From: Laura Gibbons <Laura.Gibbons@arun.gov.uk>
Sent: 12 October 2021 14:19
To: Planning.Responses <Planning.Responses@arun.gov.uk>
Cc: Maria Tomalova <Maria.Tomalova@arun.gov.uk>
Subject: RE: Planning Consultation on: AL/114/21/DOC

Engineers Comments Regarding Condition 3

Application No: AL/114/21/DOC

Description of Works: Approval of details reserved by condition imposed under AL/136/17/PL relating to Condition No 3 - surface water drainage.

Scale	As shown	At original	A3
Drawing Number	2112/SK4	Revision	-

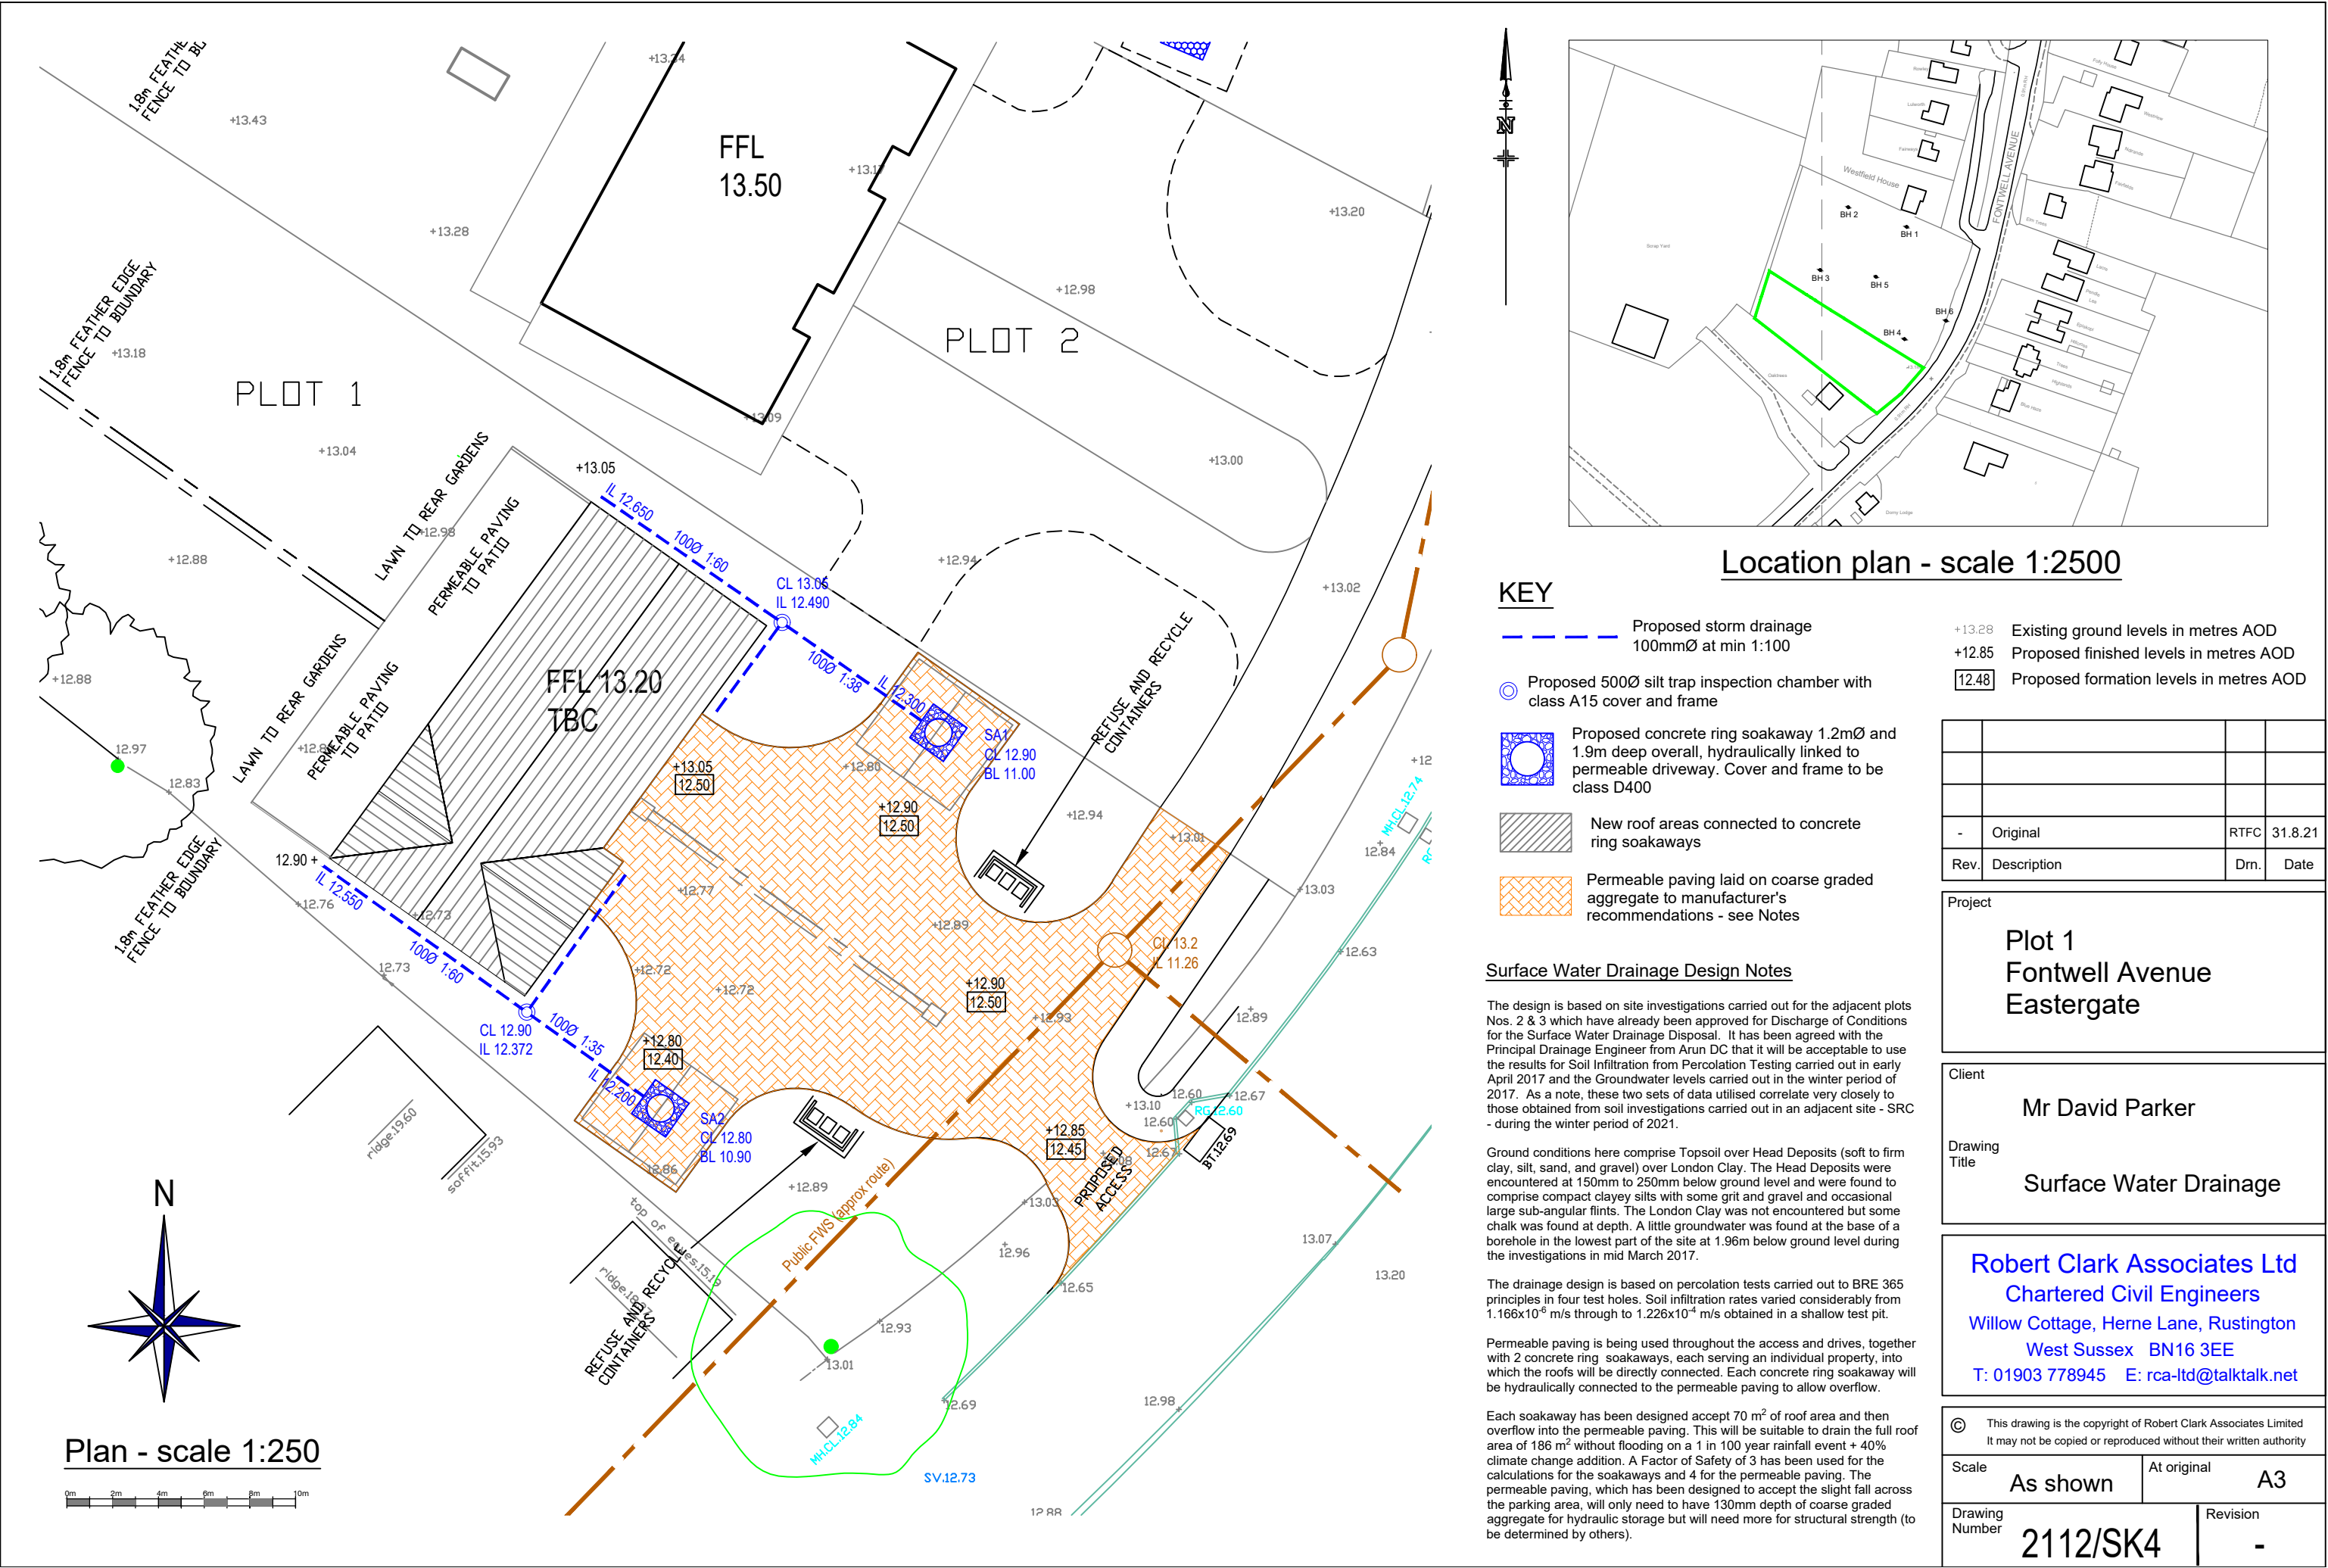
Please can the applicant supply further details of the previous infiltration testing, i.e. results from all four infiltration tests including obtained rates, depth and location of testing.

If this information cannot be supplied then we request that further testing is completed this winter at the proposed location of infiltrating features.
